**WELWYN HATFIELD BOROUGH COUNCIL
EXECUTIVE DIRECTOR - PLANNING, PUBLIC PROTECTION AND GOVERNANCE**

DELEGATED APPLICATION

Application No: 6/2021/2943/FULL
Location: 19 Thornton Road Little Heath Potters Bar EN6 1JJ
Proposal: Conversion of loft to habitable use including the installation of 1 x rear dormer and 4 x front rooflights
Officer: Ms Kirsty Shirley

6/2021/2943/FULL

Drawing N°: ELA/6 Rev: B

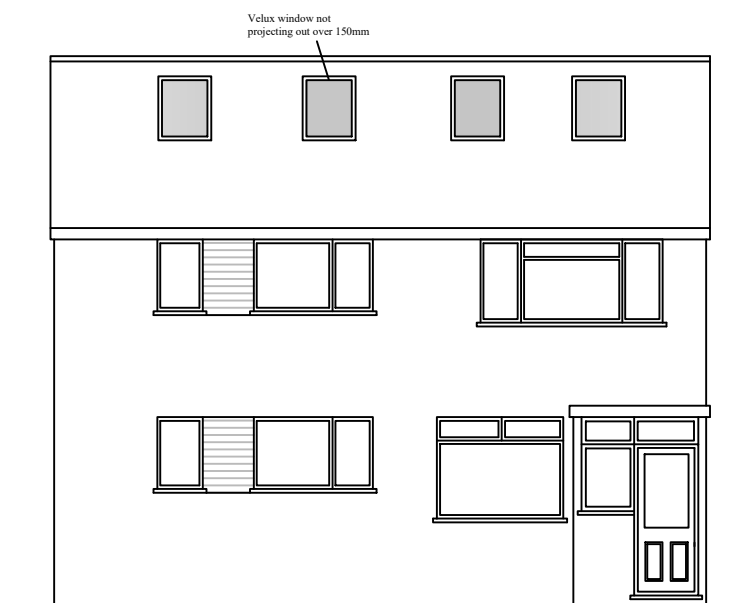
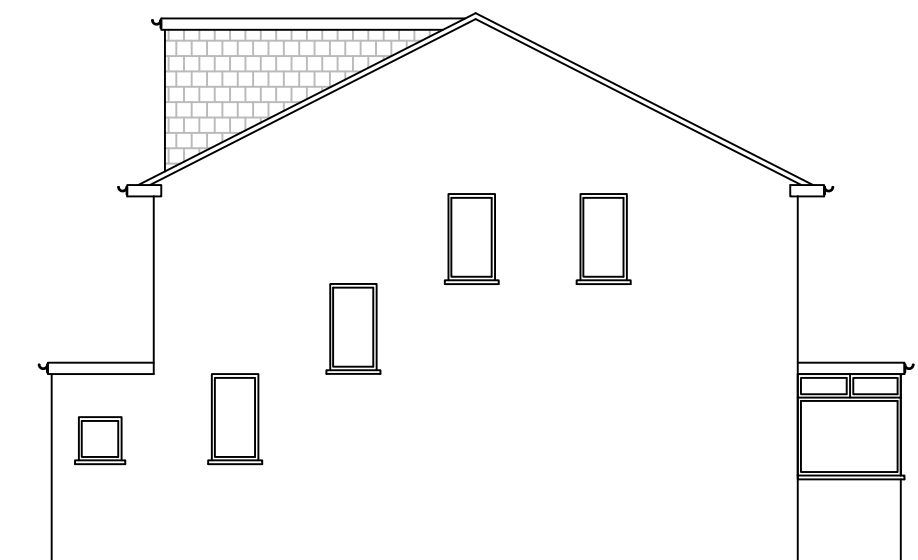
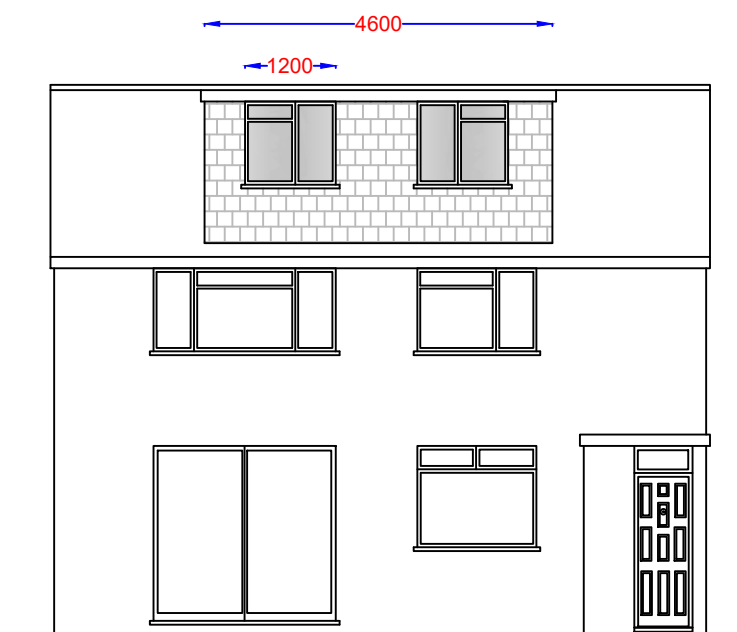
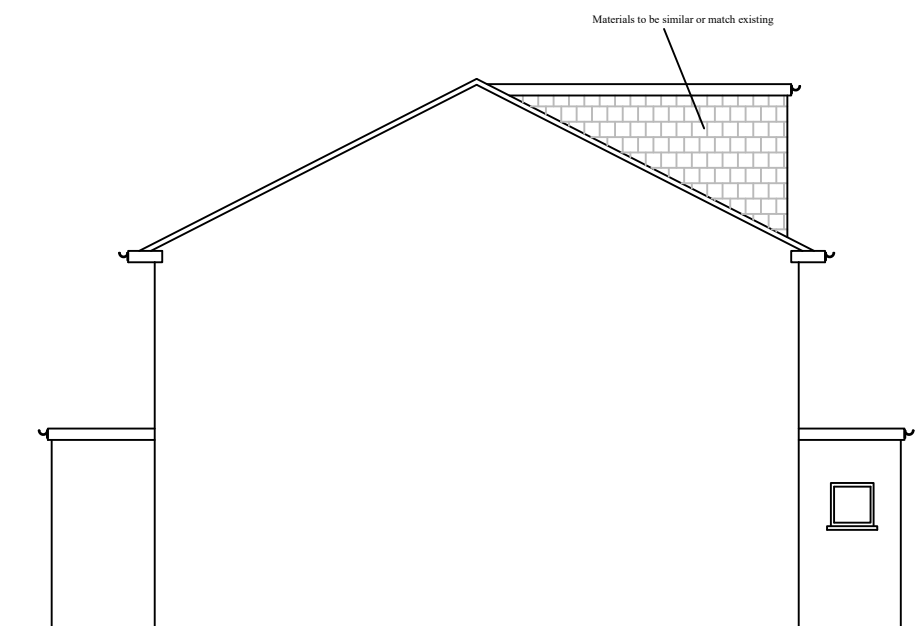
The proposed dormer would be contained within the roof slope, set below the ridge height of the property with the dormer cheeks of the window set in over 1m from the flank elevations of the property. The size and scale of the dormer window would appear subservient to the existing dwelling and the fenestration of the dormer would be in keeping with the existing fenestration within the rear elevation. Due to the positioning of dwellings within the street, there would be very limited views of the dormer window from public vantage points and subsequently limited harm to the street scene.

Four front facing rooflights are also proposed to facilitate the conversion of the loft into a habitable space. The rooflights would be equidistant across the roof slope and would be consistent in size and scale. Front facing rooflights are not predominant within the street scene but examples of front facing rooflights are noted within the area, and it is considered that the proposed roof lights would not detract from either the application dwelling or the character of the area. Matching materials can be secured by condition to ensure that the development remains in keeping with the application dwelling.

It is considered that the positioning of the roof lights, and the size and scale of the dormer window, would not result in adjoining neighbours to experience a detrimental loss of light or privacy, nor would the development appear overbearing towards adjoining neighbours.

1. The brickwork, roof tile, bond, mortar, windows, detailing, guttering, soffits and other external decorations of the approved alterations must match the existing dwelling/building in relation to colour and texture.

Drawing N°: ELA/13 Rev: C

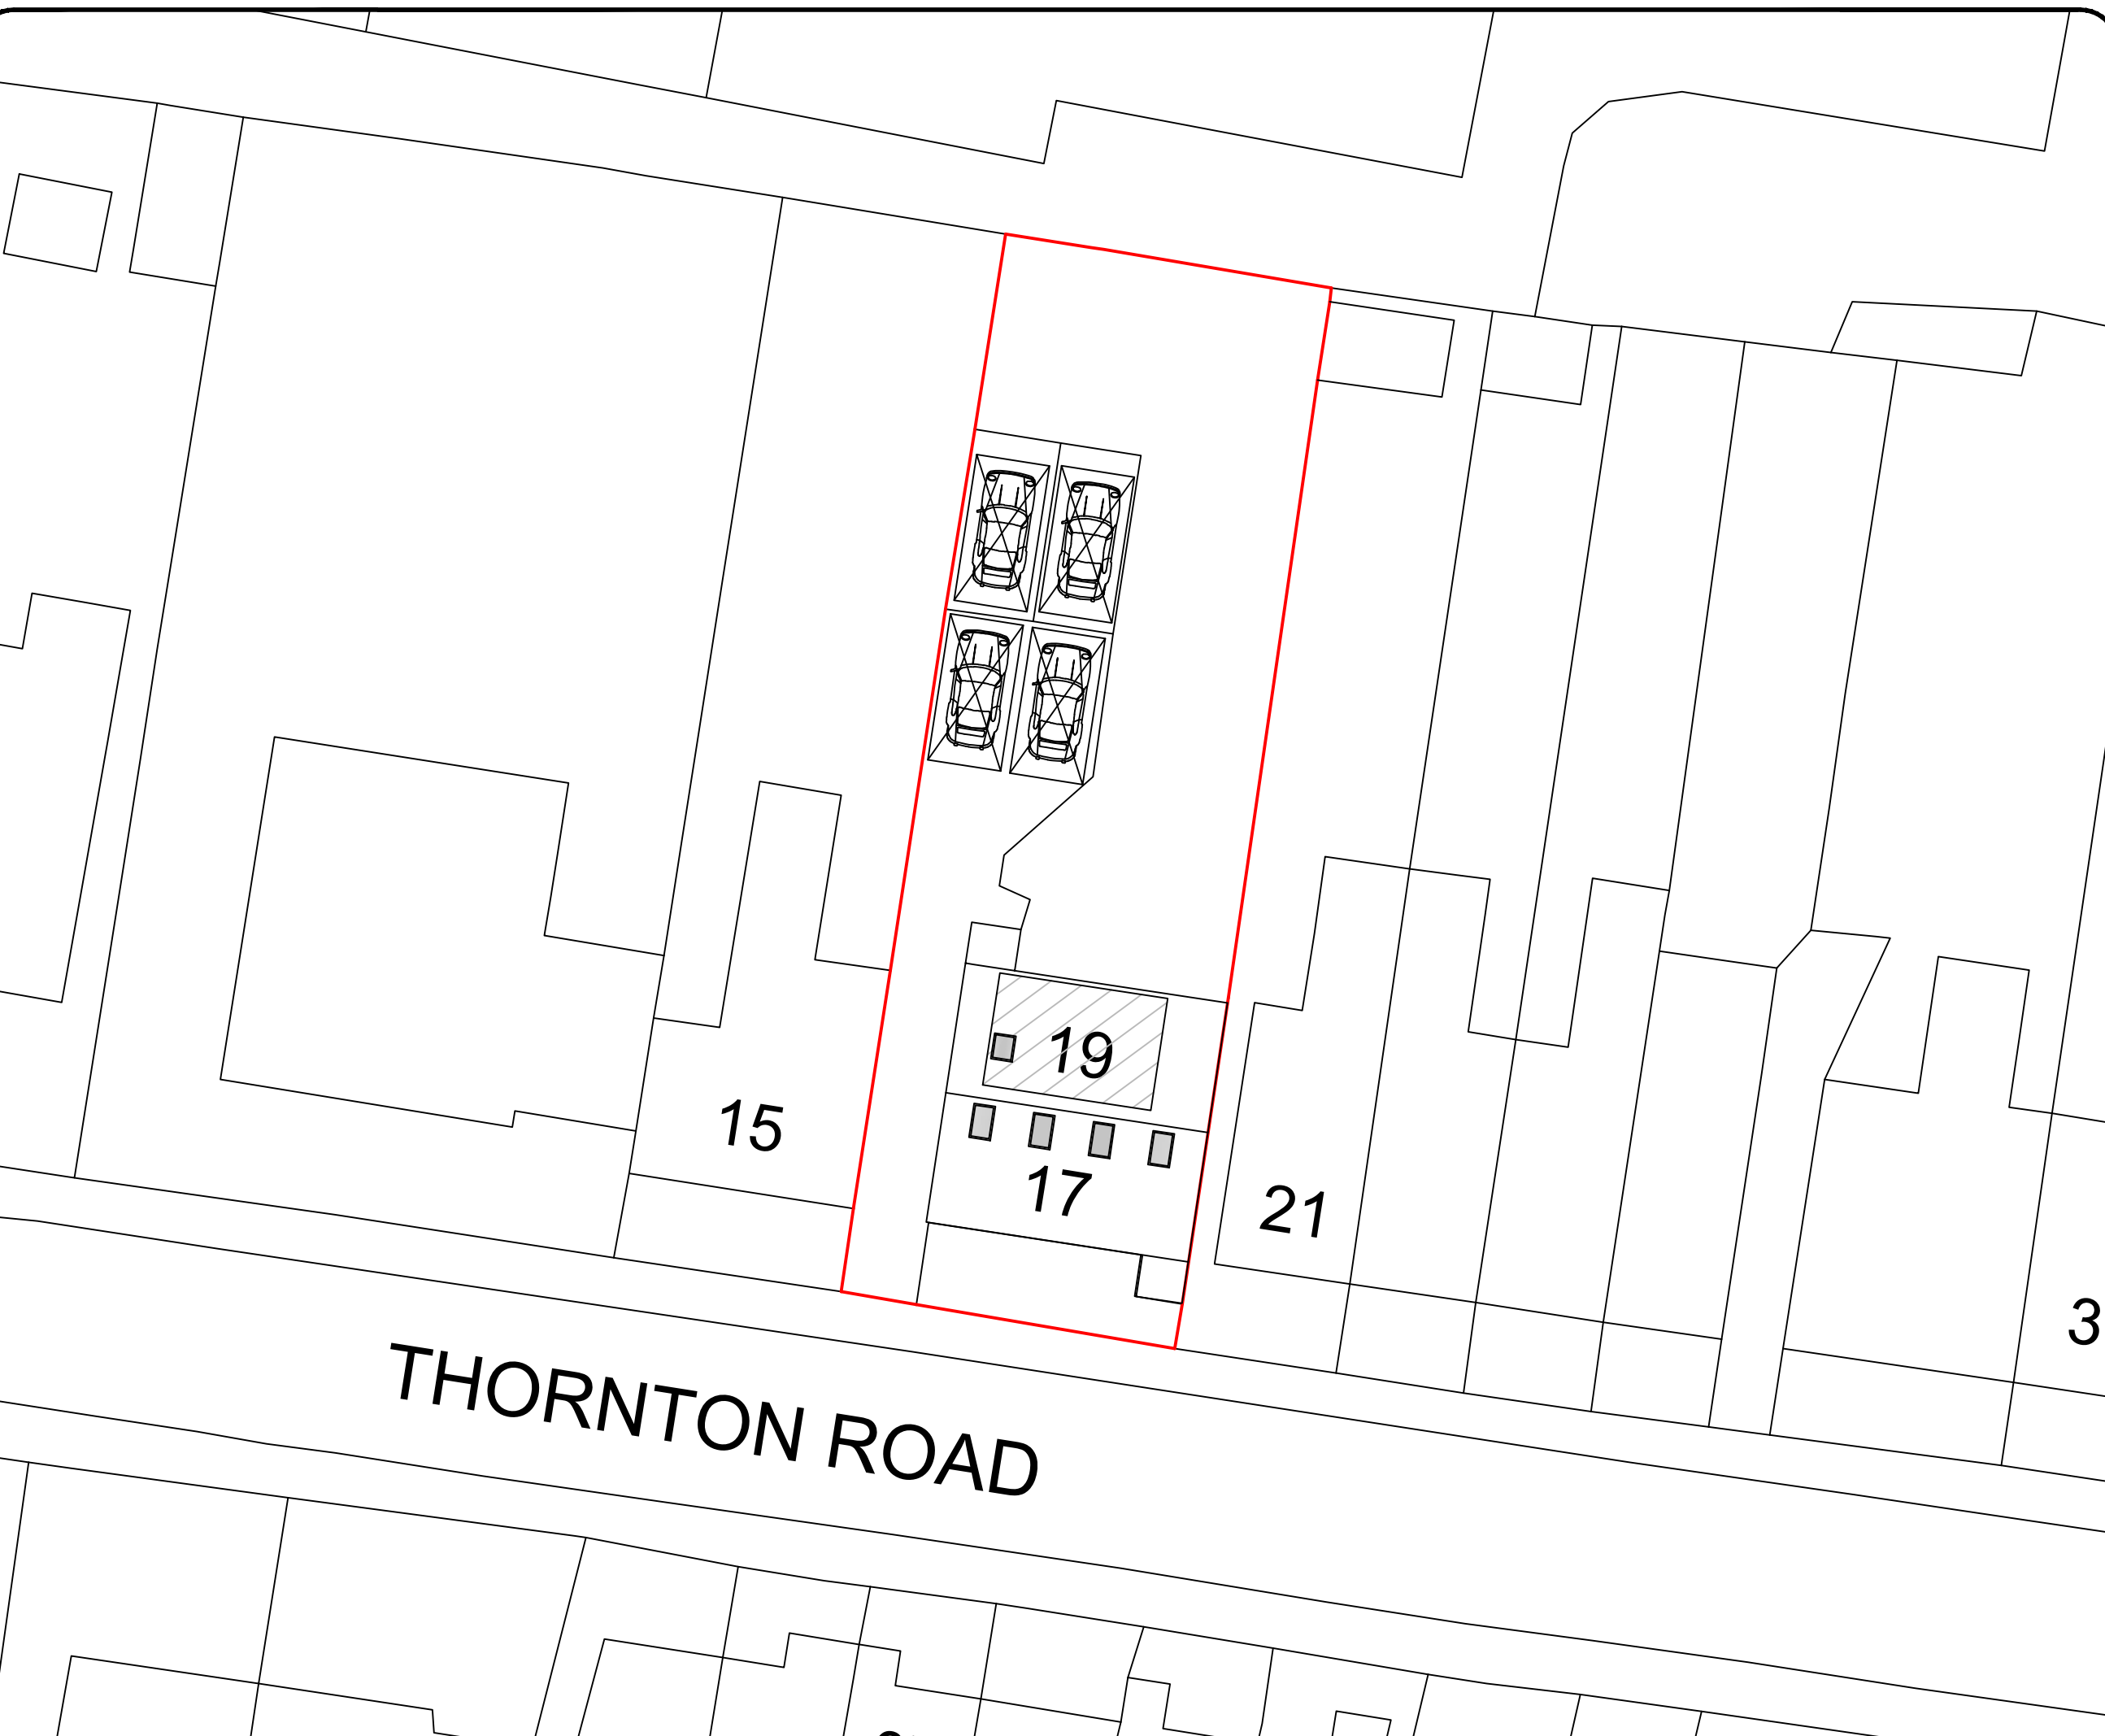
The proposal would increase the amount of bedrooms from two to three. The Council's Car Parking Guidance advises that a three bedroom property in this location should provide 2.25 car parking spaces. The application property is a flat located above No. 17, and the application site has an elongated driveway to the side of the property leading to two attached garages.

The applicant has confirmed that one of the garages belongs to No. 19. The garage measures approximately 2.8m by 5.8m, and whilst the Interim Policy for Car Parking Standards and Garage Sizes advises garages should be 6m by 3m to accommodate a modern vehicle, it is considered that the garage in this case could accommodate vehicle parking for one vehicle. The applicant also states one vehicle parks in front of the garage, and this is replicated by adjoining neighbours No. 17 with their garage.

From a recent site visit from public vantage points, it is clear there is car parking pressure in Thornton Road. The majority of dwellings on Thornton Road do not benefit from on-site parking but there are no car parking restrictions and many vehicles park on the street. Furthermore, a bus stop is located approximately 0.1 miles away from the application site, and shops and services are located approximately 0.6 miles away. It is therefore considered in this case that there is sufficient car parking provision for the proposed development.
